November 12, 2021

Re: OSH – Montano Rd
333 Montano Rd. NW
30-Day Temporary Certificate of Occupancy
Transportation Development Final Inspection
Engineer's/Architect's Stamp dated 8-4-21 (F14D023)
Certification dated 11-10-21

**CONSTRUCTION
DETAILS**

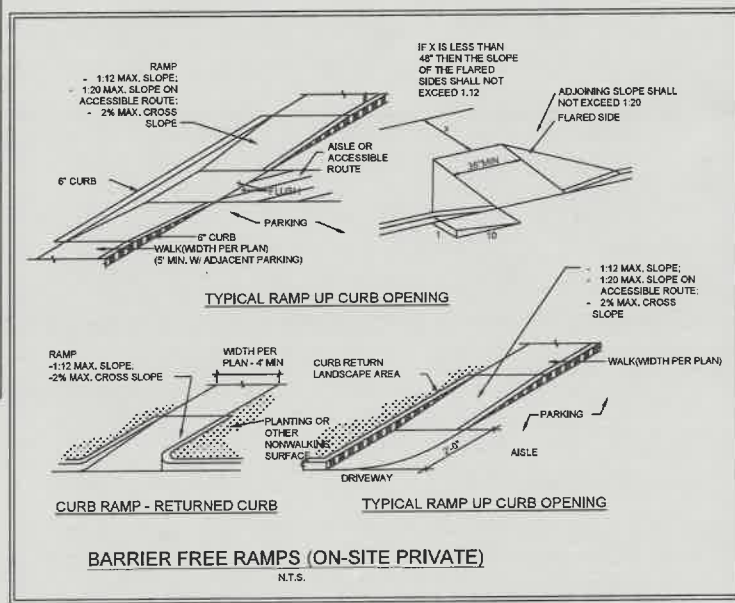
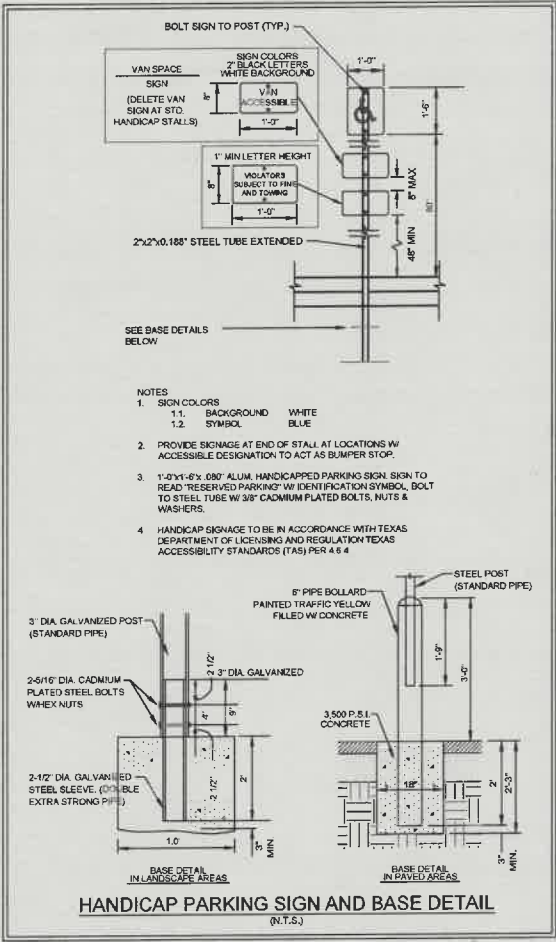
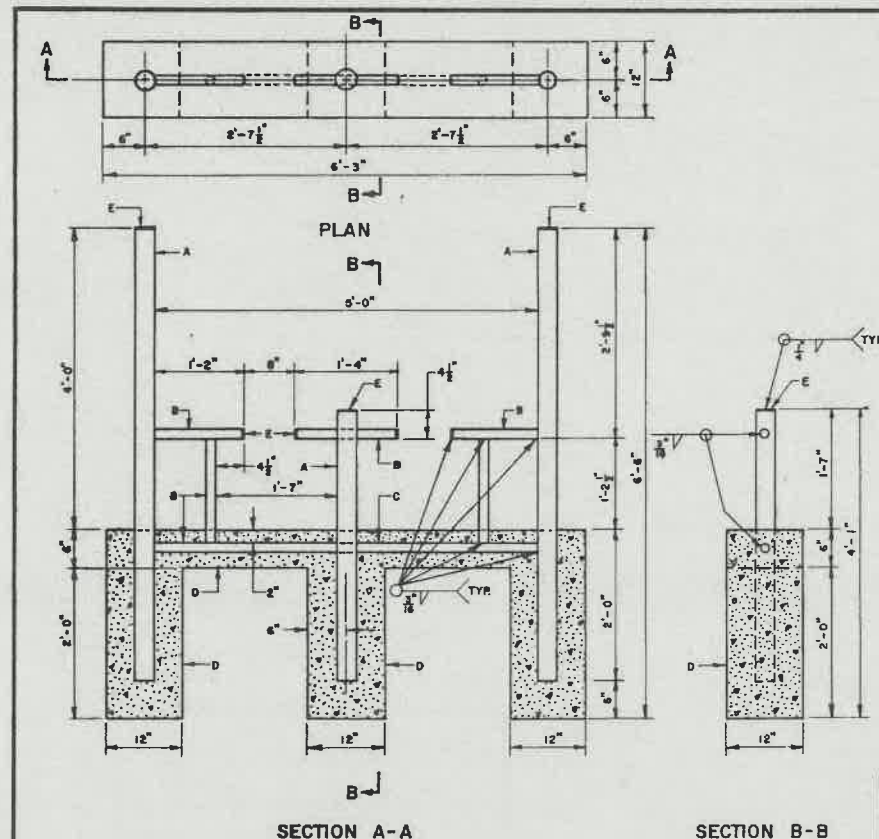
- The ADA access aisle shall have the words "**NO PARKING**" in capital letters, each of which shall be at least one foot high and at least two inches wide, placed at the rear of the parking space so as to be close to where an adjacent vehicle's rear tire would be placed. (66-1-4.1.B NMSA 1978)
- The ADA accessible parking sign must have the required language per 66-7-352.4C NMSA 1978 "**Violators Are Subject to a Fine and/or Towing.**" If that language is present it is not visible in the detail.
- Complete Landscaping.
- Remove porta potty, construction equipment and debris from site.
